F2006/01080 RJL/jd

16 September 2016

Exhibition Wallarah 2 Coal Project – Amended Application – SSD-4974

Figure 5.6 Predicted Total Subsidence Contours

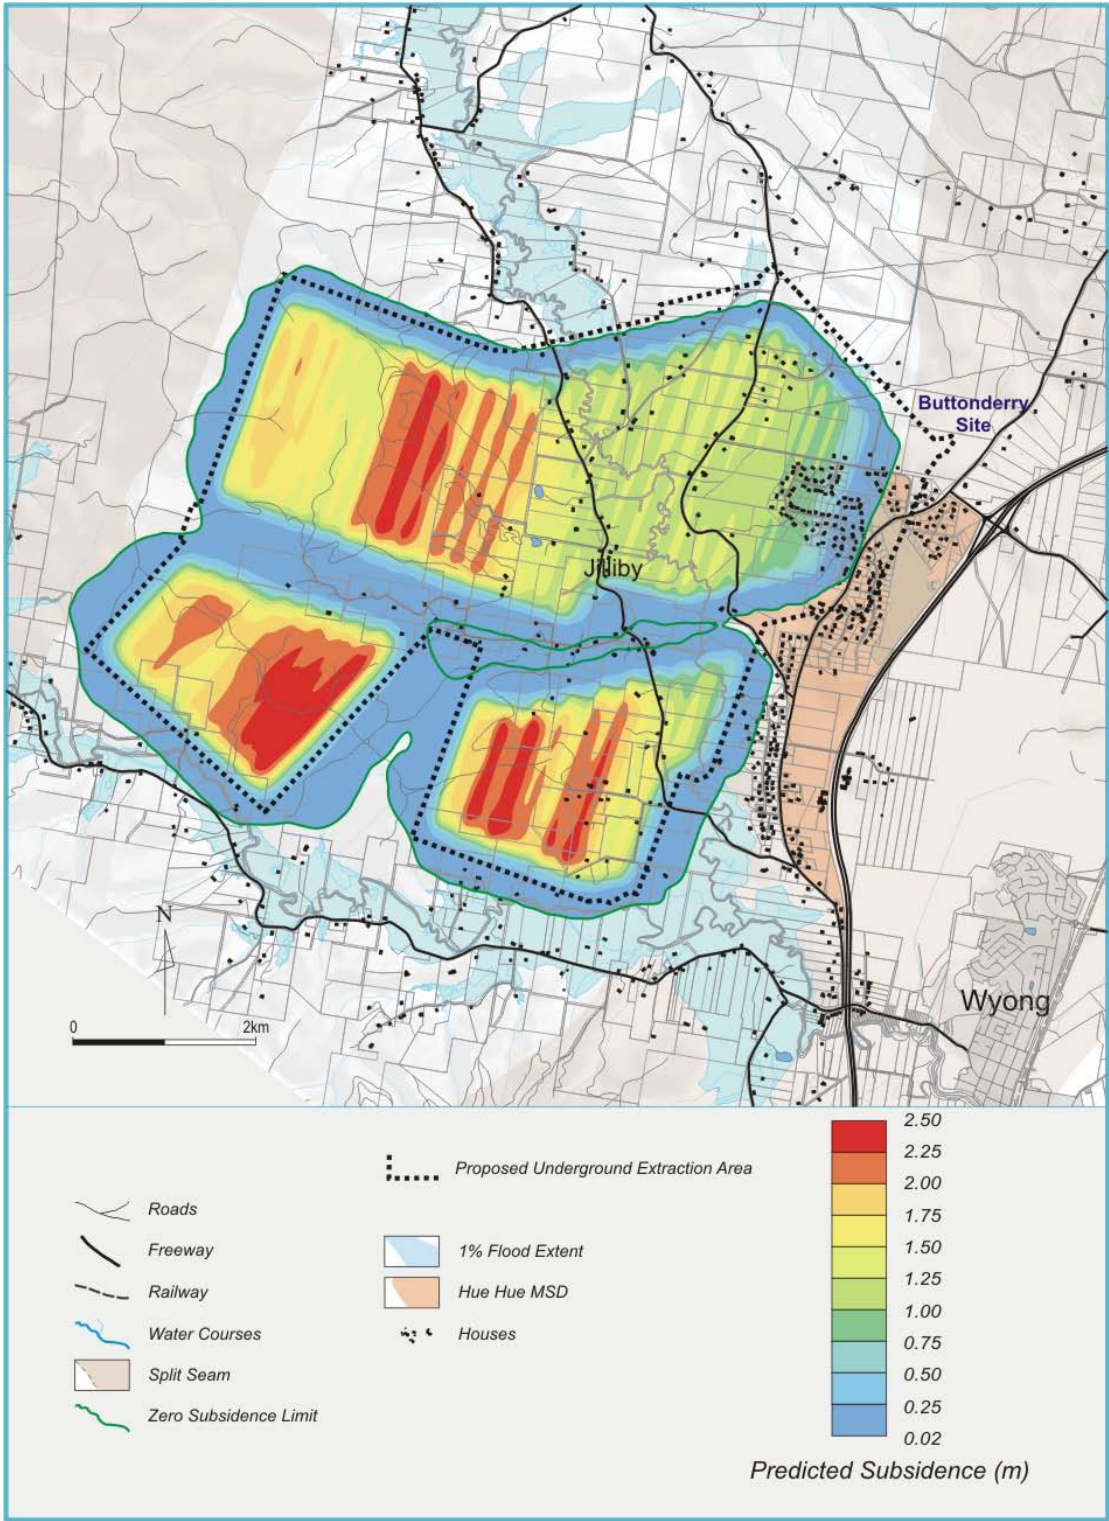
The prime result of mining are the expected number and severity of impacts across the 245 properties within the area affected by the predicted subsidence, viz:

- 83% of properties being unaffected;
- 12% requiring very minor to minor repair;
- 5% requiring substantial to extensive repair; and
- <0.5% requiring a complete rebuild (i.e. about 1 property).

These impacts are based on predictions of subsidence comprising:

- Vertical subsidence up to 2.6m with less subsidence predicted in residential areas to the east and more subsidence within forested areas to the west.
- Tilts up to 15mm/m concentrated above the edges of the panels and over forested areas.
- Tensile strains up to 4mm/m concentrated near the edge of panels. About 99% of these strains are expected to be less than 2.5 mm/m.
- Compressive strains up to 5.5 m/m concentrated about 50m inside the panel edges. About 99% expected to be less than 3.3 mm/m.
- Far field movements up to -60 mm horizontally at a distance of around 1km from mining diminishing to less than 25 mm at a distance of 2 km.

PSM does not agree that the prediction represents a conservative estimate of subsidence impacts as all the evidence presented in the EIS suggests the prediction represents the most likely impacts.

PSM considers that the model, calibration and application of the prediction does not provide sufficient guidance as to the sensitivity and reliability of the method and may, therefore, fail the Director General's "reasonable level of confidence" test.

In general PSM did not find any omissions or evidence to suggest that subsidence due to W2CP is likely to be significantly different to that predicted by the EIS. PSM's main concern is the lack of certainty around the predictive method and the likely variation in prediction based on observed variations that are already known and potentially those unknown.
